**Arun District Council** Date inspected: 15<sup>th</sup> November 2019

**Planning Application Ref:** AW/246/19/PL

**Location:** Land Adjacent to 34 Wakefield Way Aldwick PO21 3RS

**Description of works:** Erection of 1 No. 2 storey end of terrace house

Site Plan

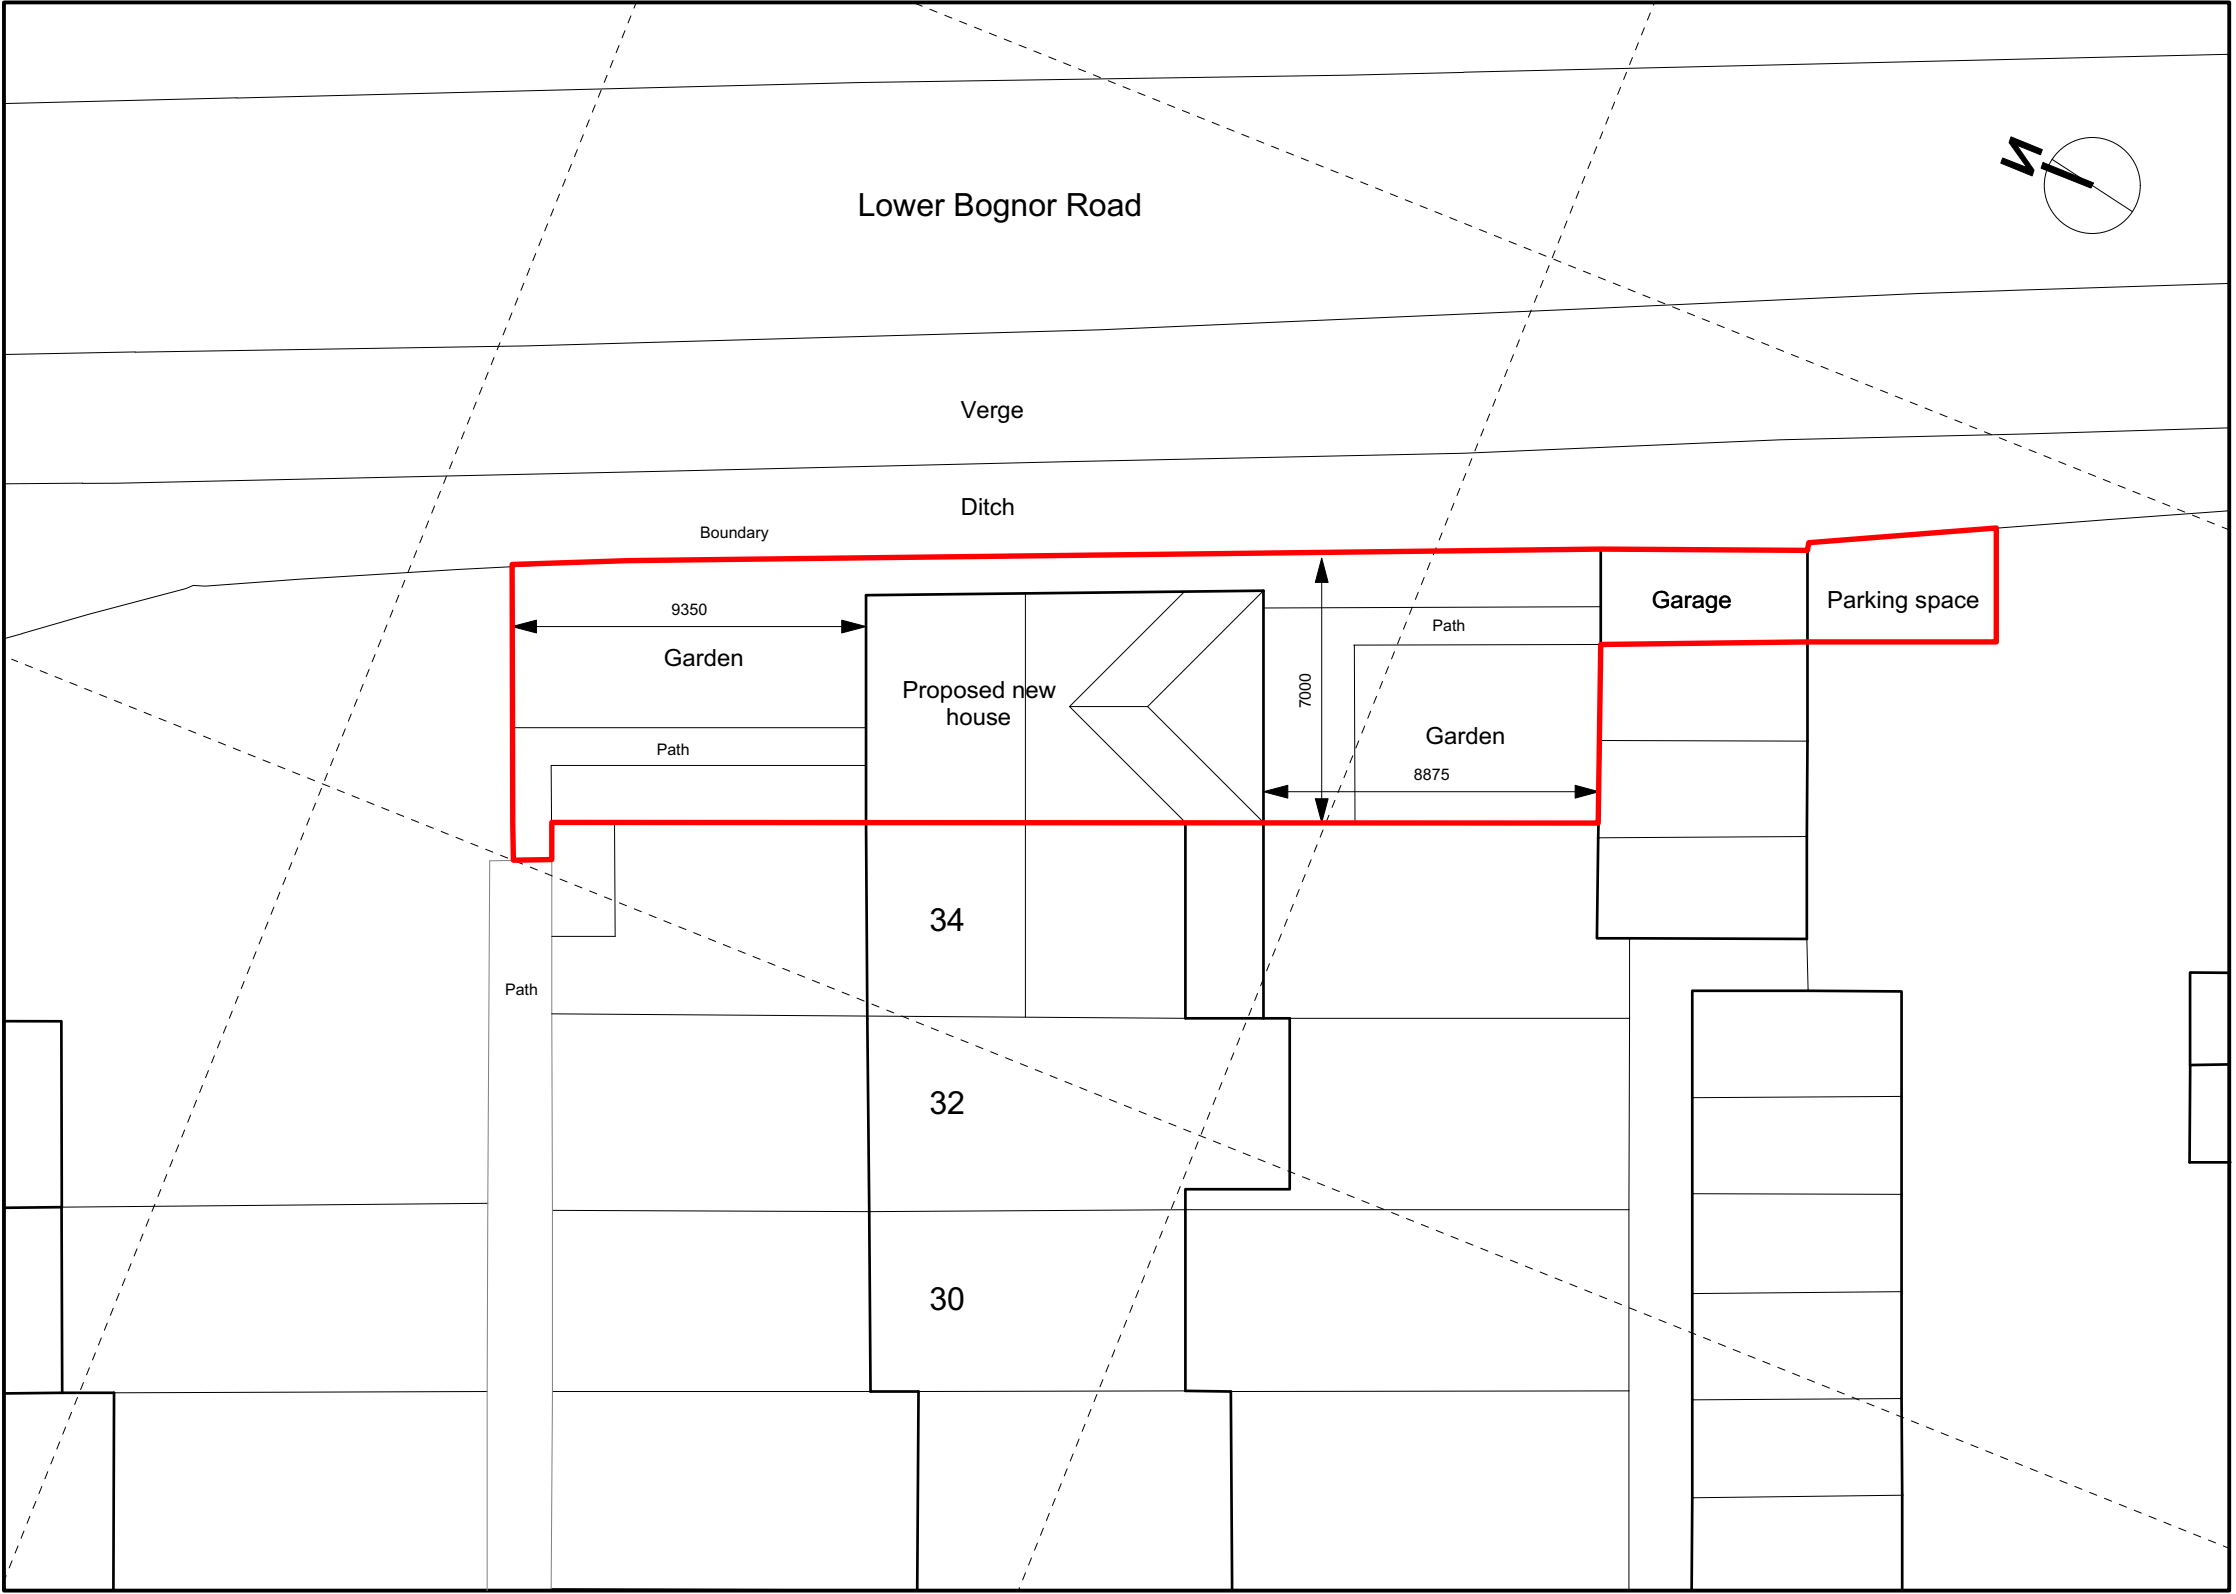
- I note from the Design and Access Statement that cellular soakaways are proposed (ideally to be 5m from built structures) and that should be situated outside of the anticipated rooting area of established trees. I have not seen where this is going to be located but clearly to the rear of the dwelling is going to be problematic, especially when you revise the RPA.

*The proposed cellular soakaways will be located within the proposed front garden and outside of RPA's*
